**Application 3/2021/0275**

**Location: Land behind The Dog Inn, Market Place, Longridge PR3 3RR**

**Proposal: Proposed erection of 9 new dwellings and associated works**

I refer to the latest letter from United Utilities dated 1<sup>st</sup> March 2022 in which further additional information has been requested to be submitted in support of the application.

Planning Application  
Proposed Site Plan

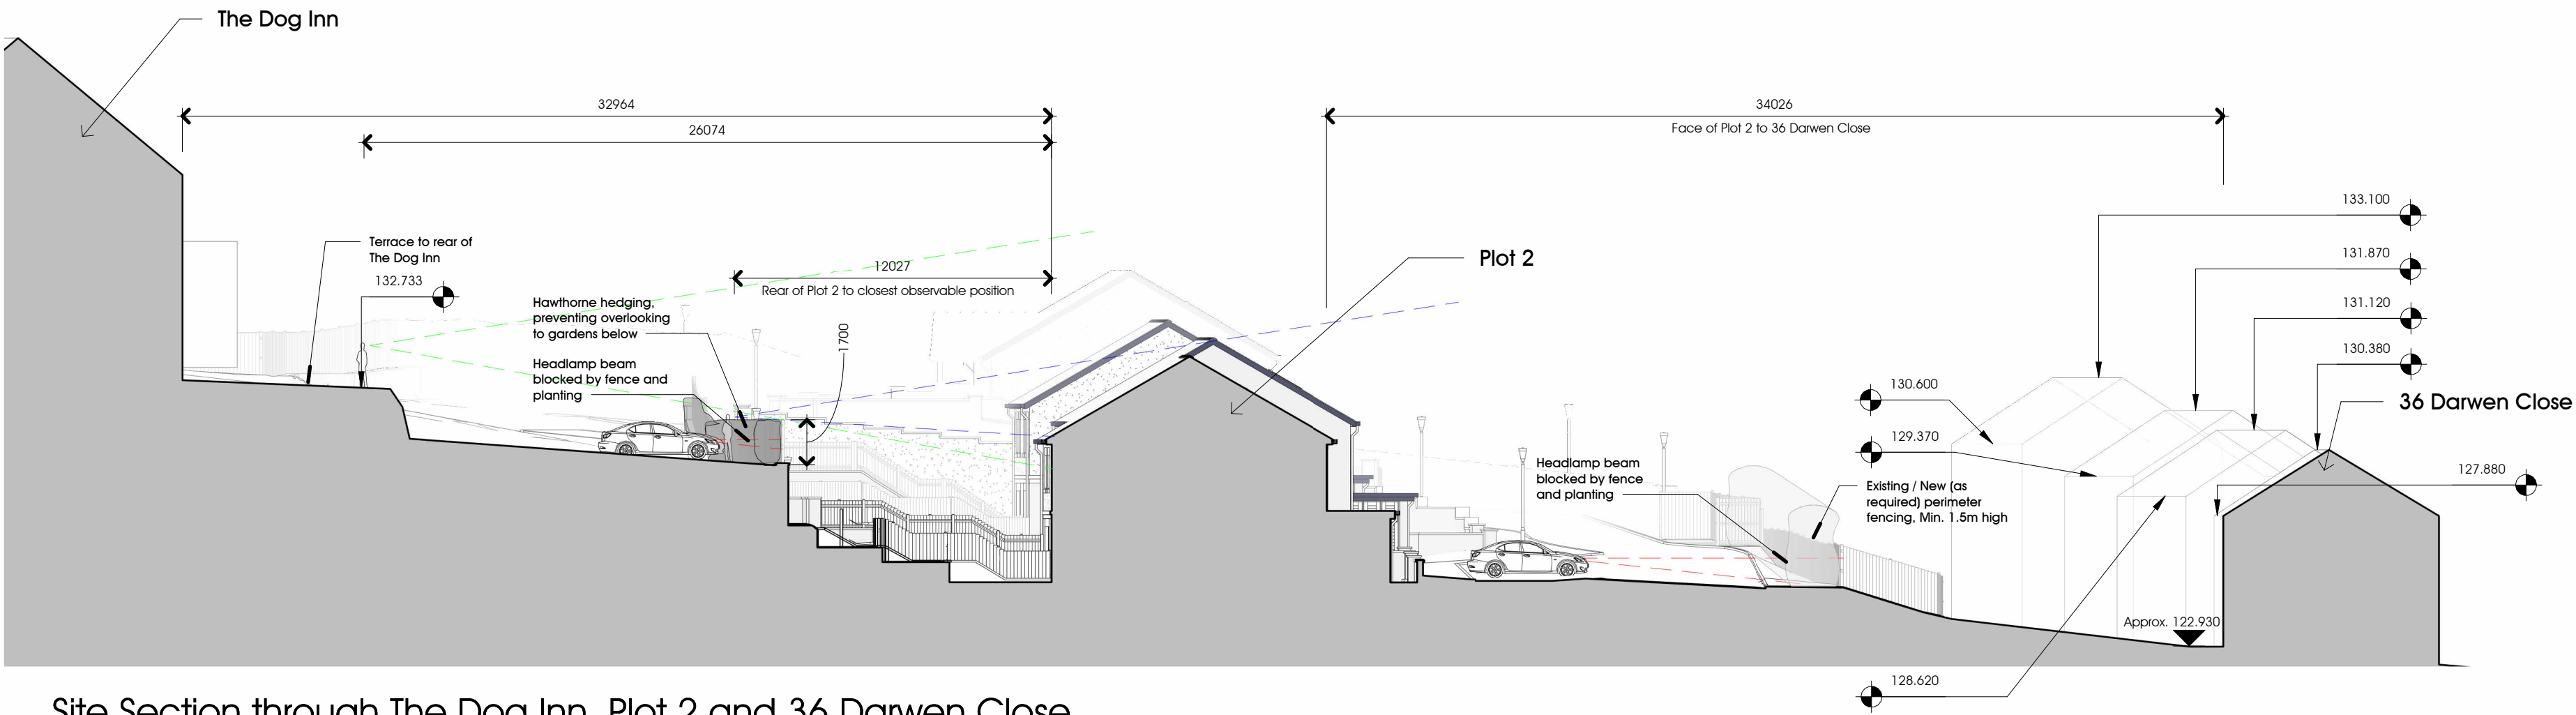
1. Cover and invert levels for the existing and proposed manholes are to be shown on the updated plans in addition to the proposed private drainage runs and connection points for each unit to the proposed drainage systems in order to enable United Utilities to complete their assessment of the proposed development.

2. Provide a plan showing kerbs or other physical features which would act to keep the exceedance flows within the road and not continue south towards the existing properties.

The drainage cover and invert levels have been placed onto the attached drainage drawing along with the connection points for each unit to the proposed drainage systems.

The exceedance flow will be prevented from continuing south towards the existing properties by the installation of high 'Trief' kerbs to be placed opposite the access road that slopes down into the development site. In addition behind the 'Trief' kerbs, the site boundary treatment along the site's southern boundary is to include a wall.

Section along existing drain

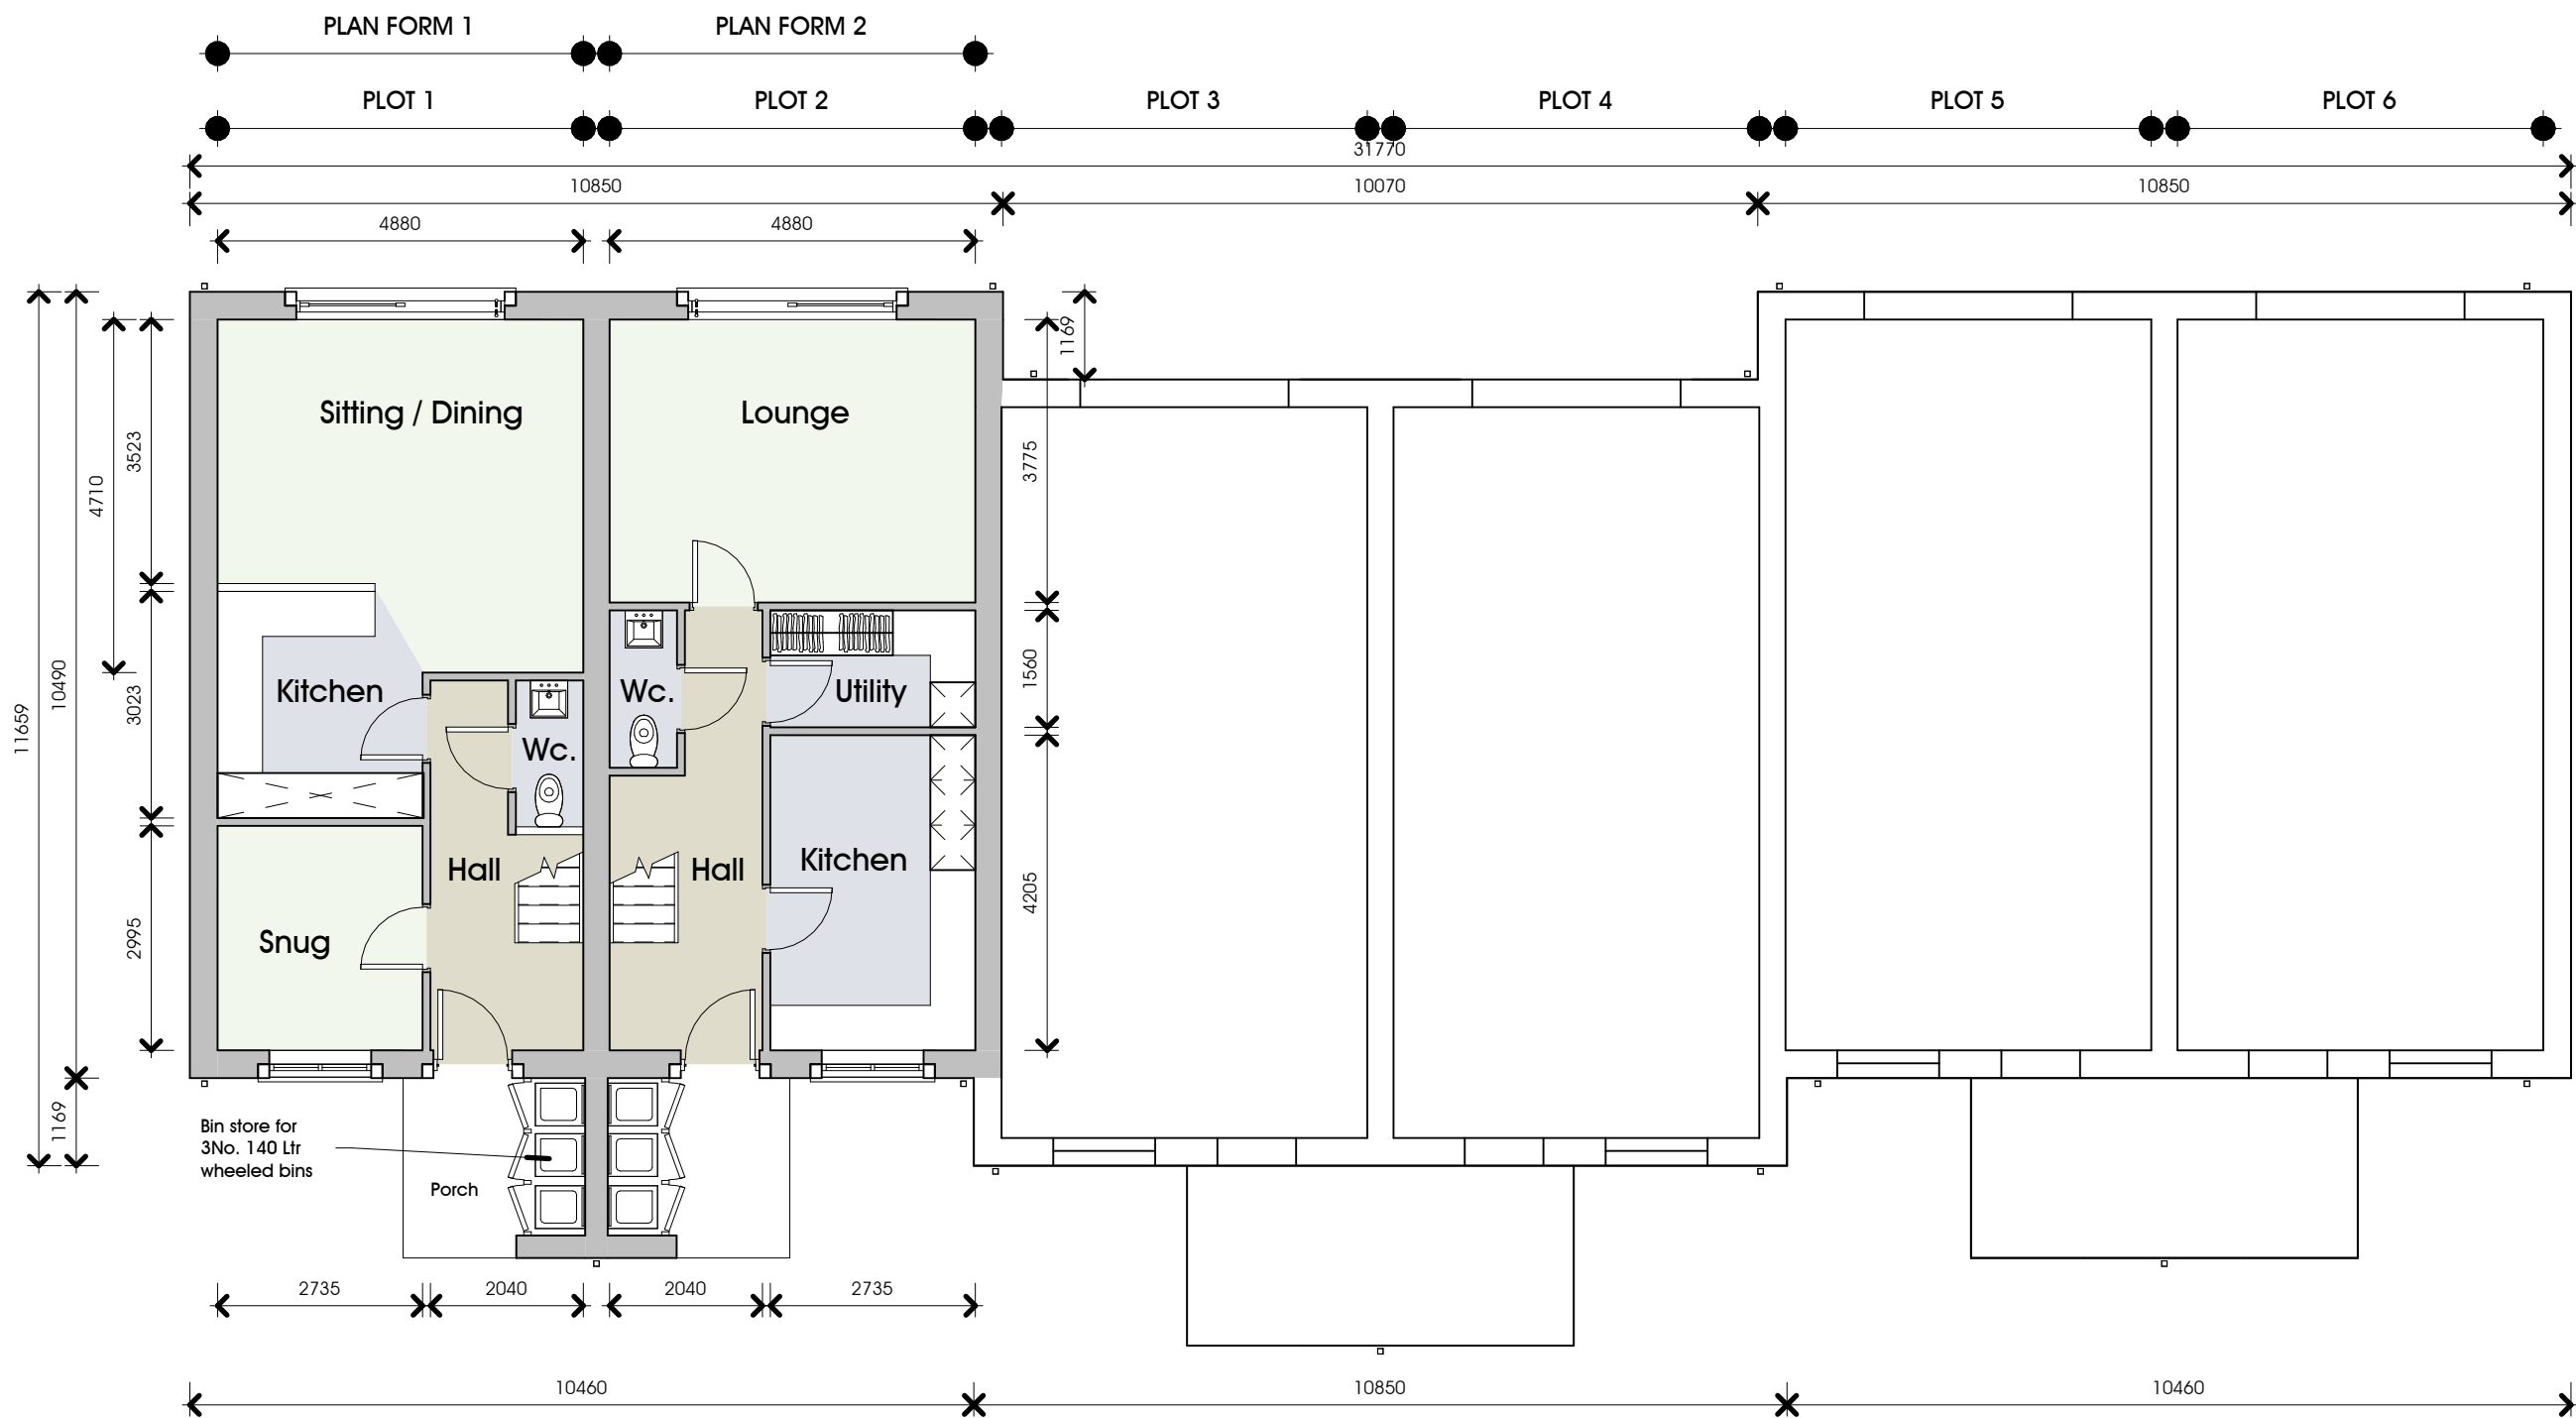
3. With regard to United Utilities previous comment regarding the proposed diversion of the public sewer within the site, development should not commence until the details of any diversion of the affected public sewer have been agreed and formally approved by United Utilities in writing. It is highly critical that the proposed diversion is assessed to understand whether any detriment that results in increased flooding potential is borne by the diversion. Therefore United Utilities would require a detailed drainage design including levels information and sewer long-sections to assess the impact of the diversion. A formal S185 diversion or design should be submitted for assessment as this may impact the proposed site layout. It is understood that the consultant wishes to agree this point by way of condition however the findings of the S185 sewer diversion assessment may result in alterations to the site layout. Without any manhole levels currently provided our previous response highlighted our concerns regarding a significant reduction in cover levels on existing manholes and the introduction of new bends.

In addition to the drainage drawing attached to this letter which includes the route of the proposed sewer diversion and level information, we also provide a long section along the proposed route of the 225mm diameter public sewer that is proposed to be diverted under a Section 185 agreement. A Section 185 application will be made on receipt of planning approval.
